Midlothian Council

**Application for Detailed Planning Permission:
Extension to dwellinghouse and extension to garage at 11 Redcroft Road, Danderhall,
EH22 1FQ**

Your Ref:
Our Ref: 21/00312/DPP

SOUTH ELEVATION

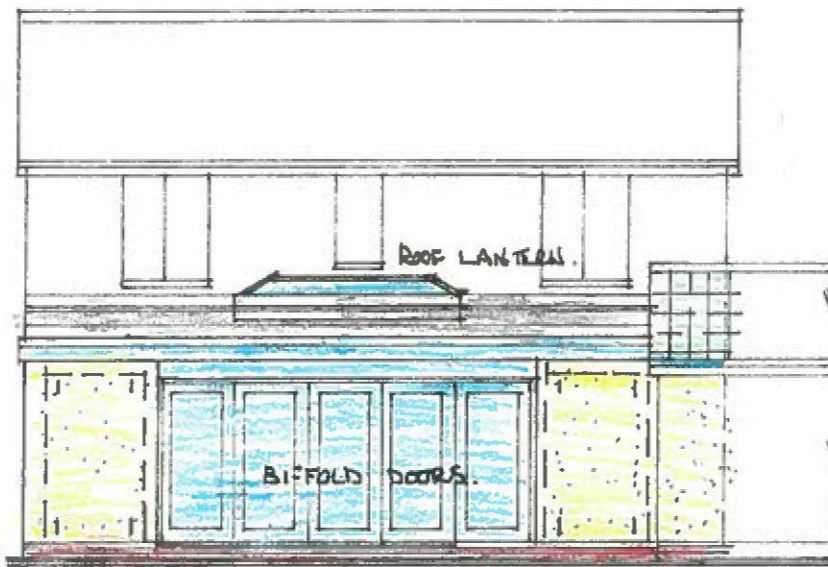
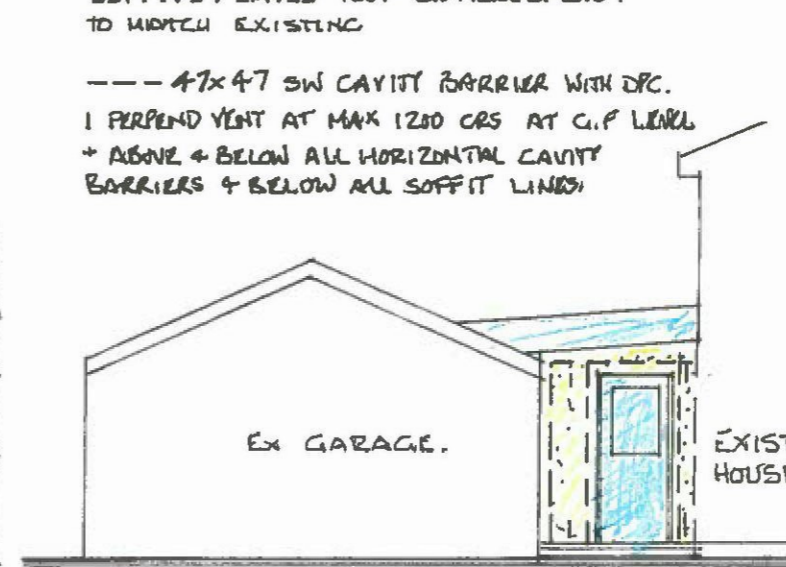
- Existing and proposed floor plan for the garage;
- Unobscured existing and proposed elevation plans of the garage and garage extension;
- The site/location plan does not match up with the proposed ground floor plan – please amend;
- It is noted that the proposed extensions to the dwellinghouse and garage may be permitted development. However, it is unclear from the submitted plans. To allow me to determine whether planning permission is required I would be grateful if you could submit a proposed site plan to show areas of hard and non hard surface and any areas of development within the rear garden.
